REQUEST

Current Zoning: R-5 (single family residential)
Proposed Zoning: UR-3(CD) (urban residential, conditional)

Approximately 0.71 acres located on the west side of Dewitt Lane, east side of Ellenwood Place, and north side of Freeland Lane, west of South Boulevard.

The petition proposes to redevelop three parcels with up to 16 residential units.

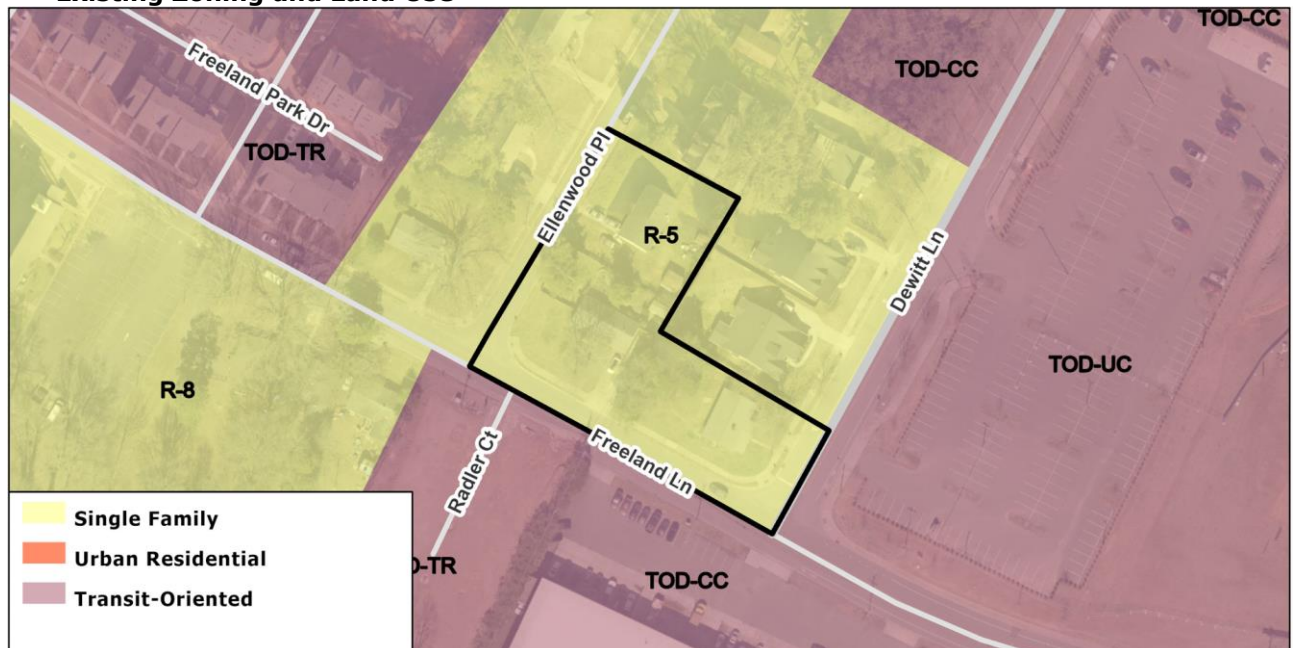
1. Provide a building form for proposed units on parcel 14901233 that better aligns with the Neighborhood 1 Place Type such as a duplex or triplex, and more closely align the building with the setback of existing single family homes.
